**App no: 3.2026.0078**

**Address: Land at Causeway Farm Longsight Road Balderstone**

**Proposal: Outline application for up to 85 no. residential units with access applied for off A59 Longsight Road.**

The submitted documents and plans, including Eddisons Transport Assessment dated November 2025 and Framework Travel Plan have been reviewed and the following comments are made.

Parameters Plan

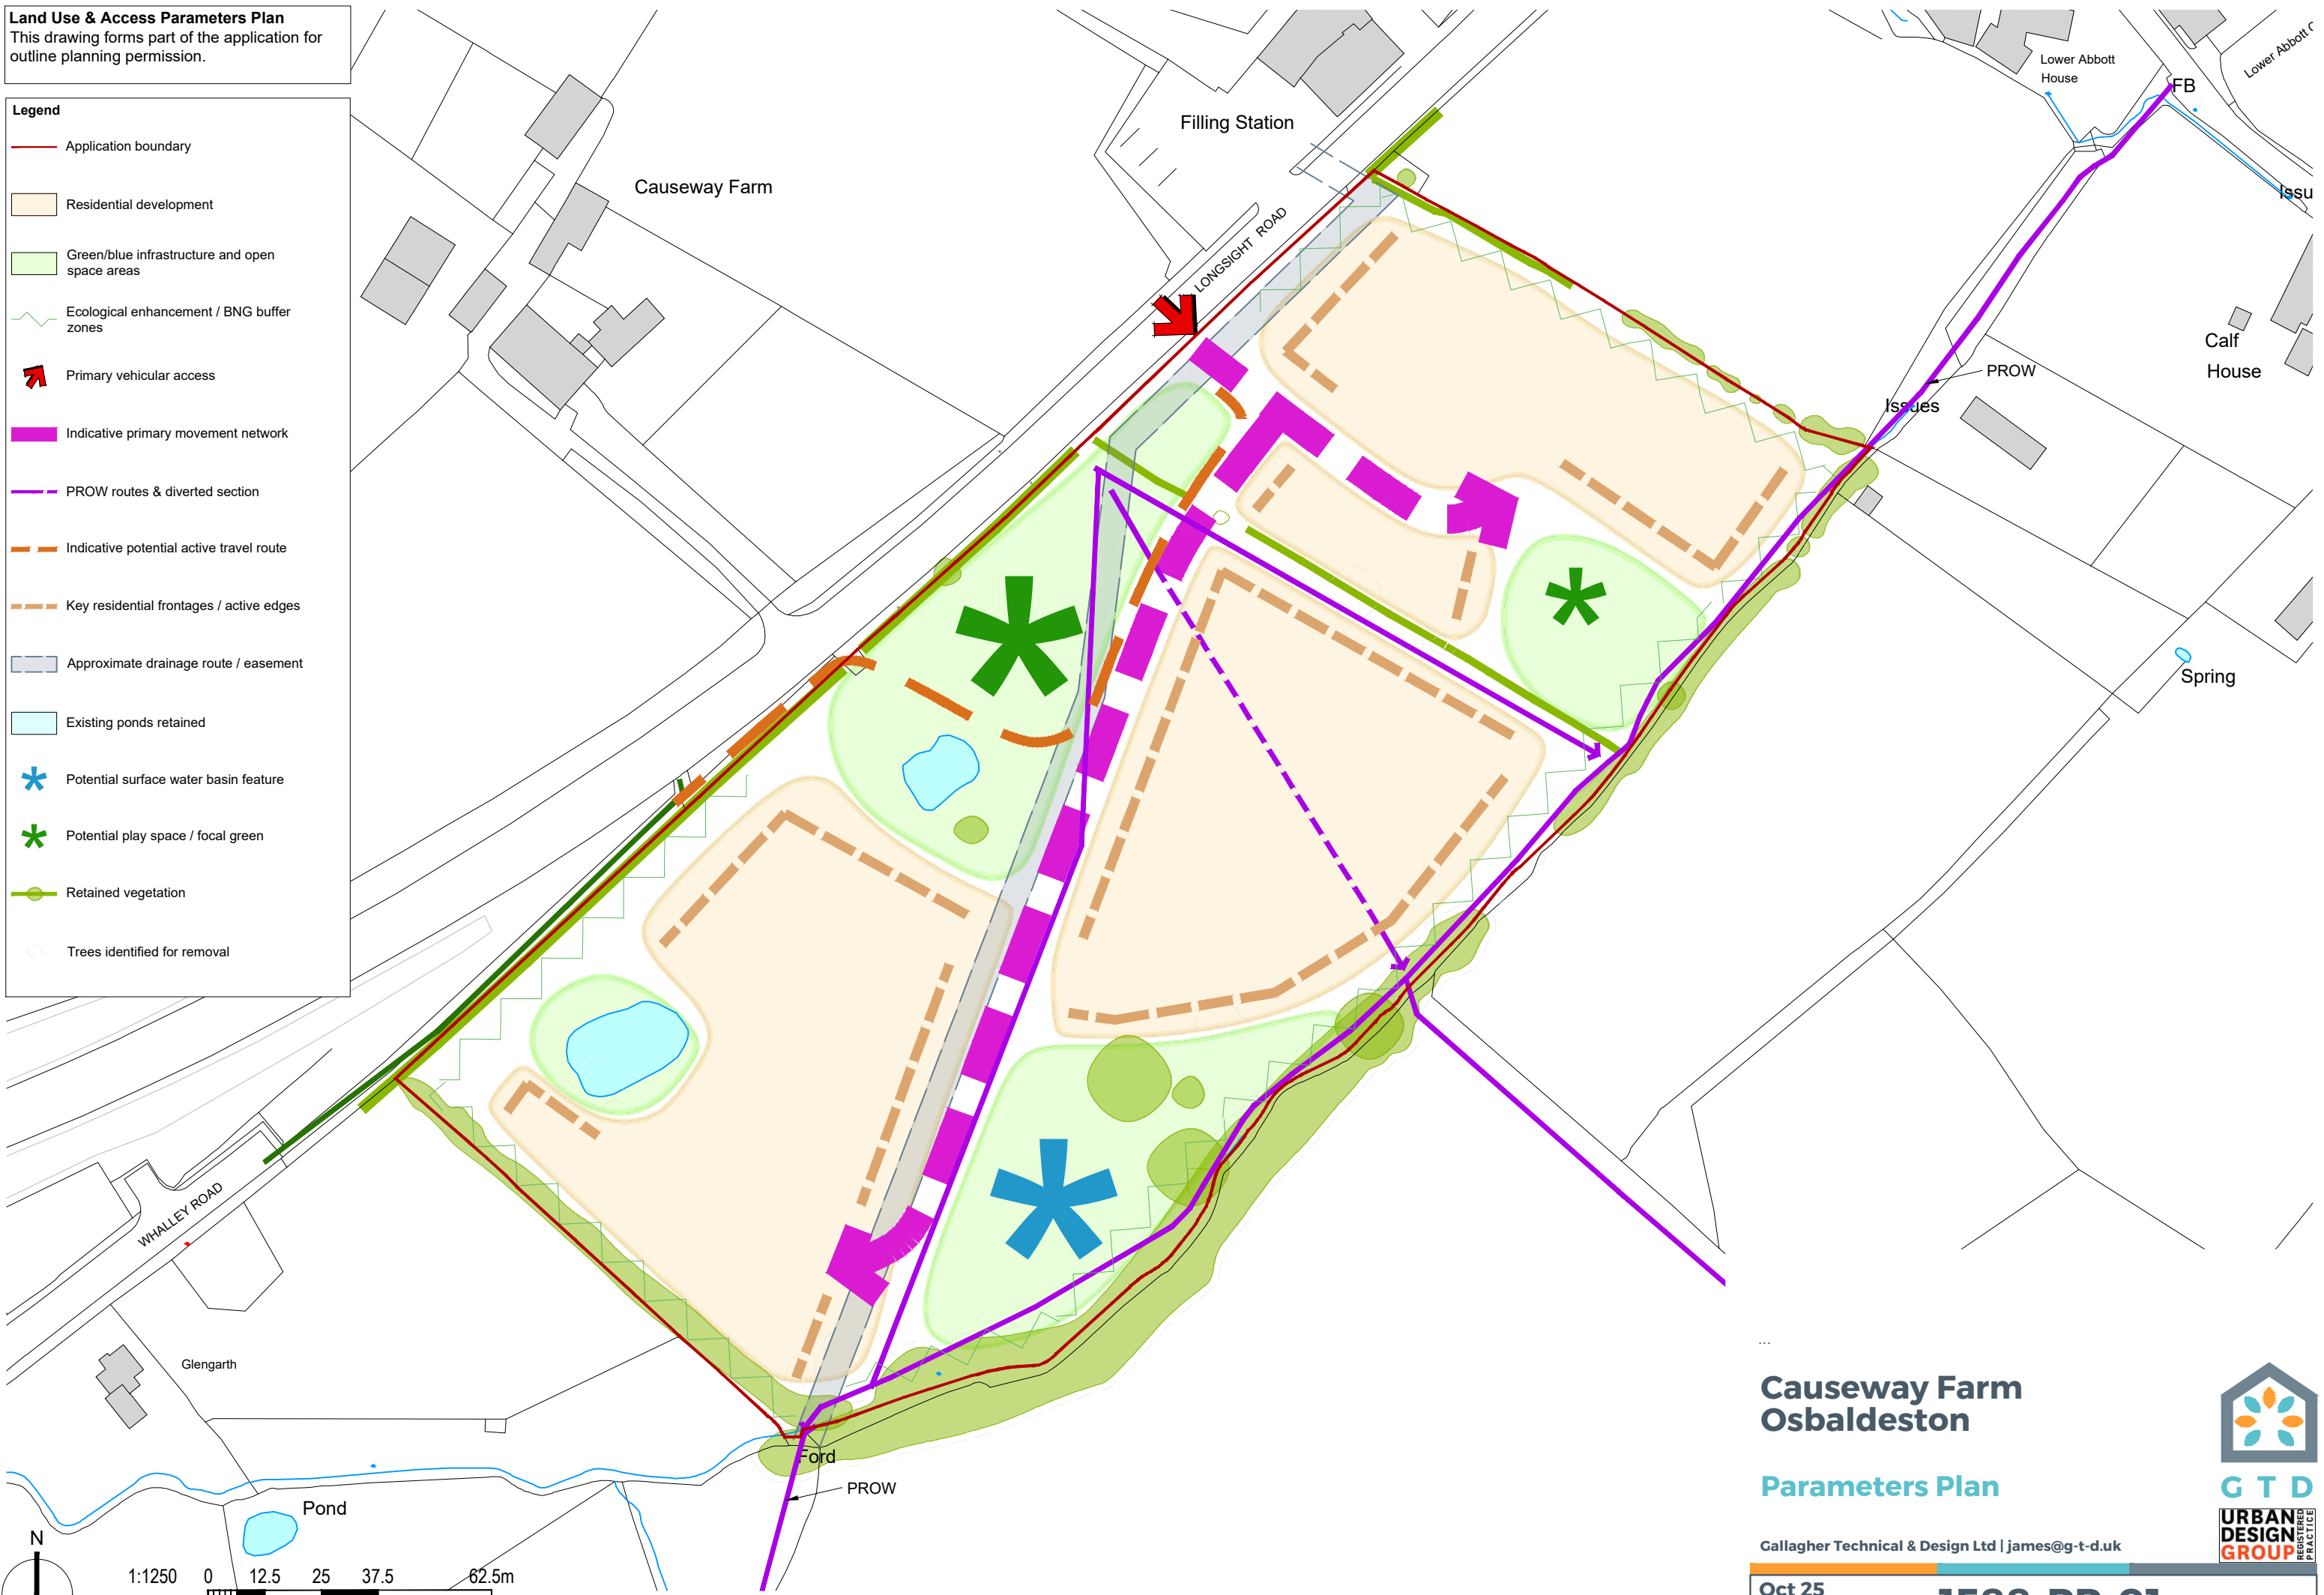
Regarding the A59 / proposed site access priority junction arrangement we consider that a right turn lane provision with central islands is necessary to safely accommodate the development traffic considered the daily flows of circa 16,000 vehicles.

We consider that the proposed site access arrangement is not sufficient to accommodate the development traffic. We consider that the estate road needs to be increased to 6m wide and the layout should include a right turn ghost lane and associated islands on the A59 to be suitable in this location.

In addition a signalised crossing is required on the A59 to support pedestrian movements.
